Your Ref: 000013580
Our Ref: FP/153/12/ 03-08-2012
Please ask for:
Miss K Rawlins

Front and rear extensions
43 Downview Road Felpham

Project: Proposed alterations; Little Thatch, Downview Road, Felpham PO22 8HH	
Drawing: Plans as proposed	
For: Mr. R. Taft	
Drawn: PKS	Date: July 2012
Scales: 1:100	No: 960/01/04
To scale when printed on A3

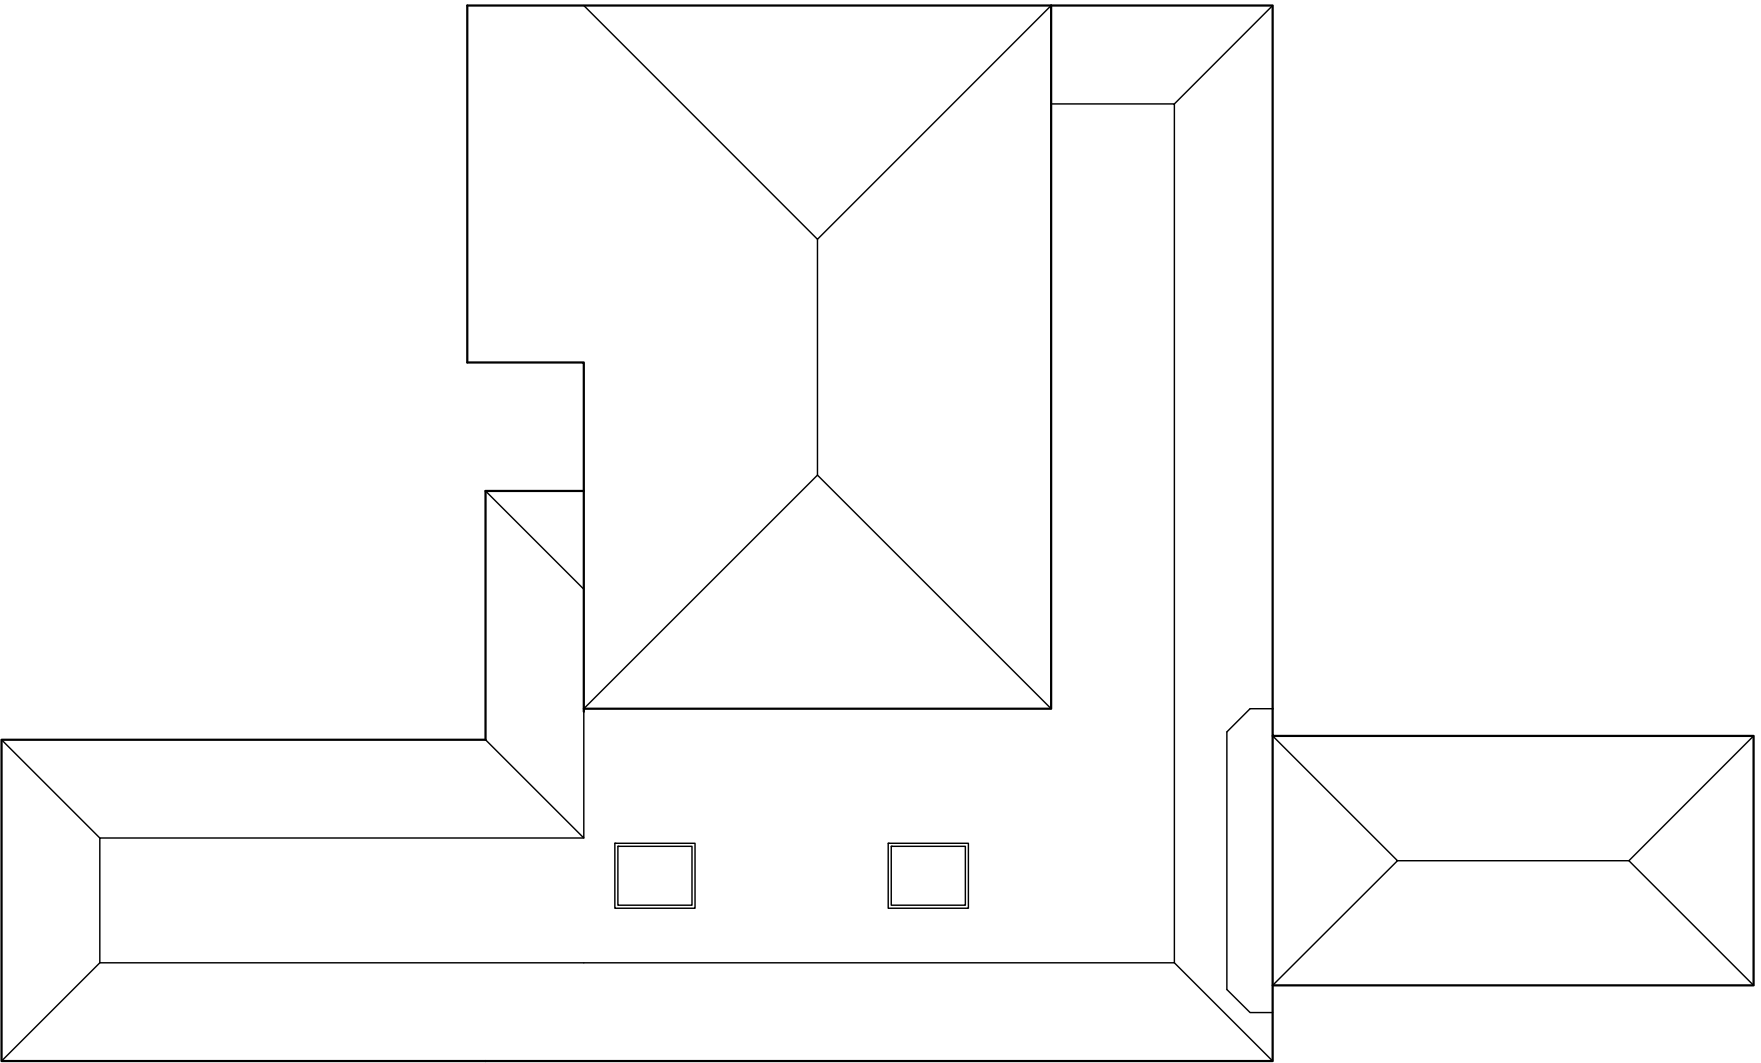
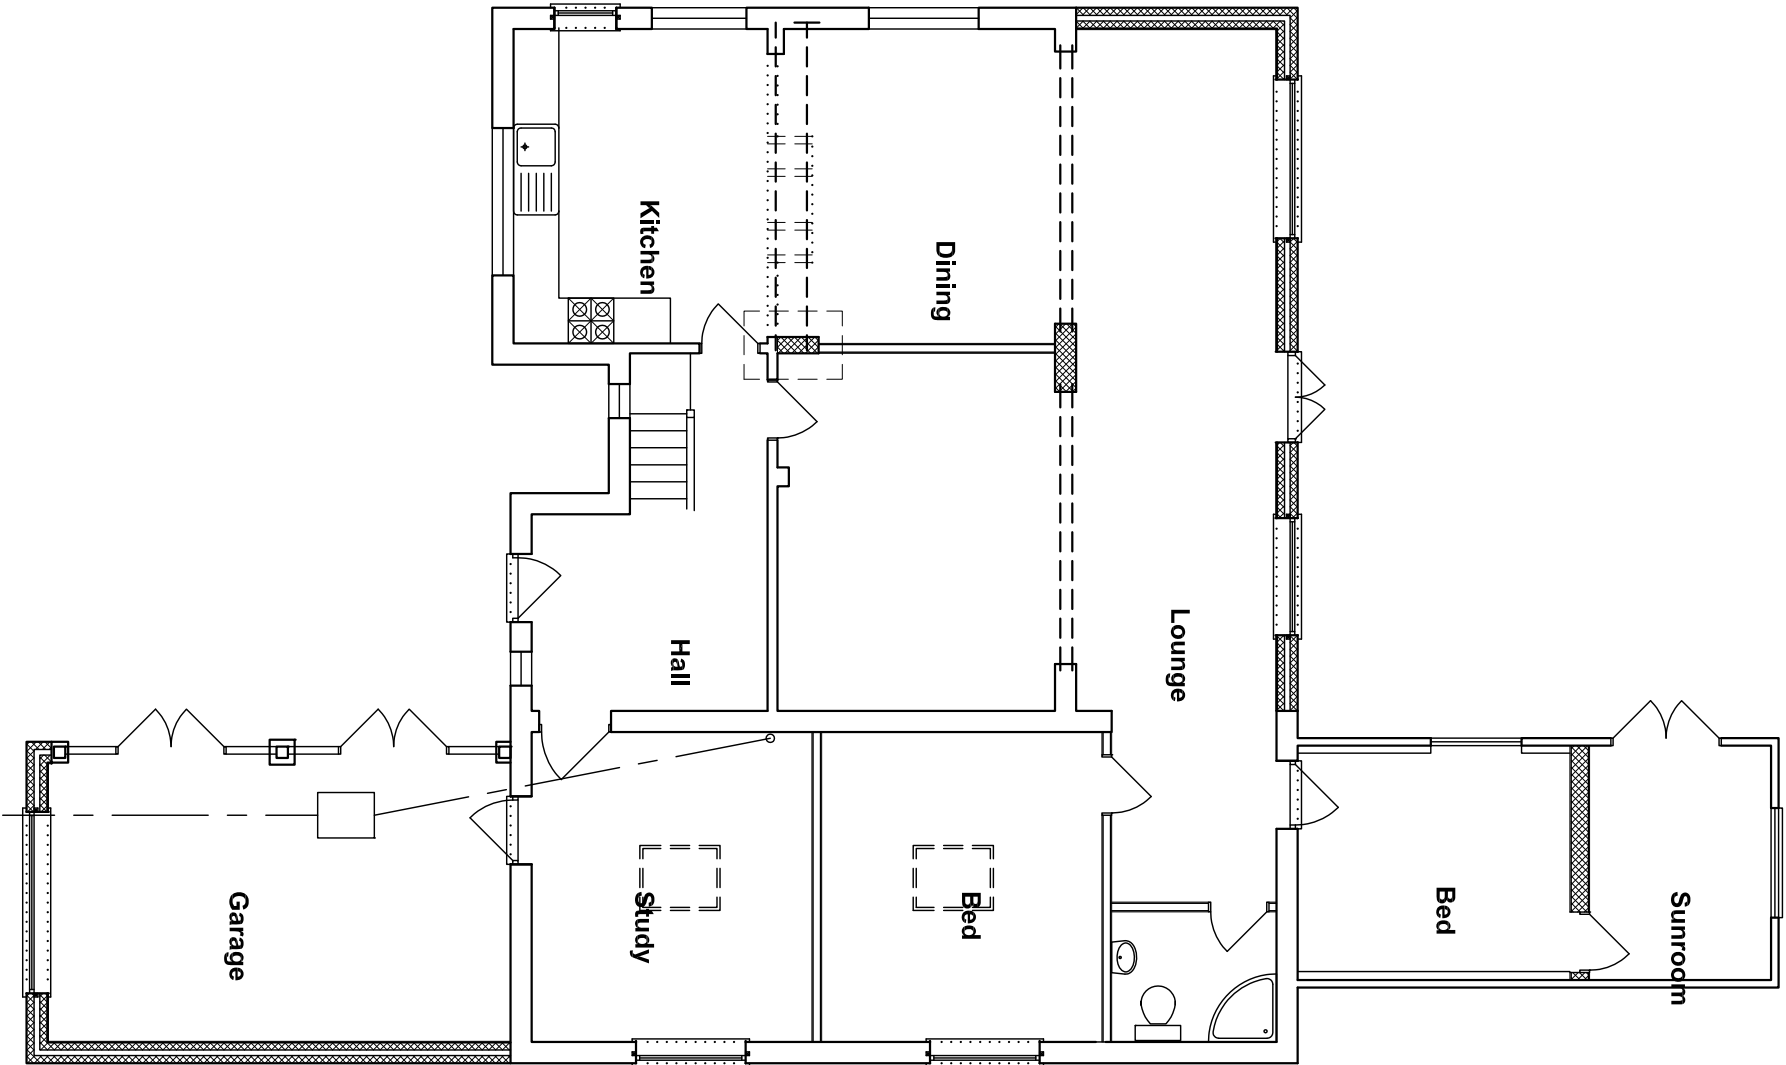
However, I would like to submit a strong objection to planning permission being granted to the proposed extension to the north east corner of the property, which is at the front of the existing building line. The application requests permission for a single story garage with a pitched roof, that extends out to the furthest building line point of my property. □

The extension will have a significant and detrimental impact upon the natural light in my living room accommodation. The building line and the height of the extension will pass a small window on the south side of my property and virtually eliminate the natural light available to the living area. Furthermore the extent of the building line will also eliminate natural light to the front bay window in the living room. □

I would like to record my objection to any development to the front of number 43 and in particular any proposal to do so on the north side of the property. □

Project: Proposed alterations; Little Thatch, Downview Road, Felpham PO22 8HH	
Drawing: Elevations as proposed	
For: Mr. R. Taft	
Drawn: PKS	Date: July 2012
Scales: 1:100	No: 960/01/05
To scale when printed on A3

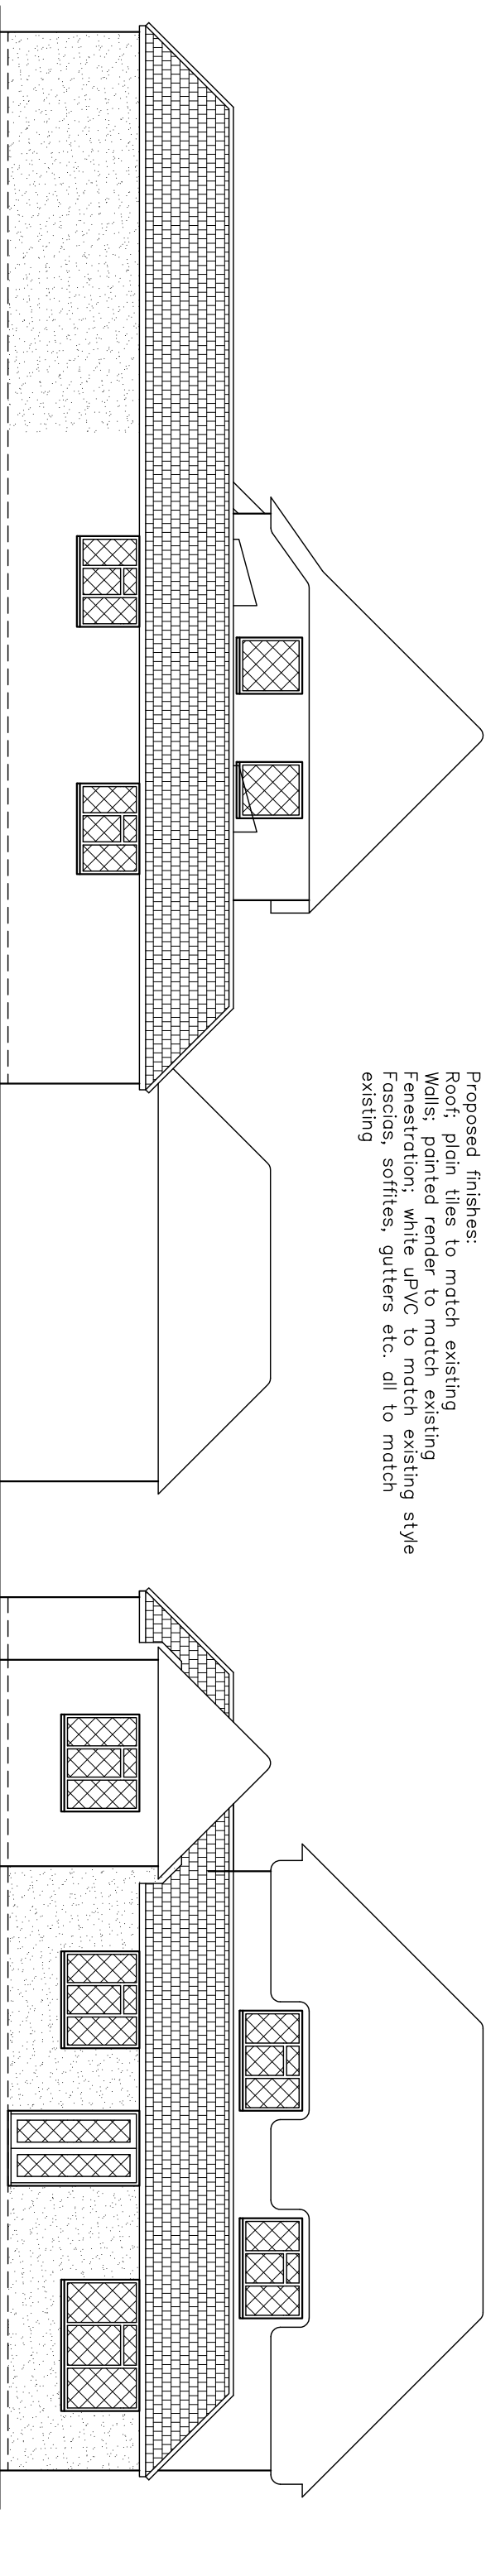
For a significant part of the year the source of the natural light will pass from east to west on the southern side of my property and the extension will act as a blockade to that, darkening the living accommodation to an unacceptable level. □

Furthermore the bay window of my property is used as a seating area and the view to the south will be completely obstructed, as well as suffering from a loss of natural light. There are no other sources of natural light to this room. □
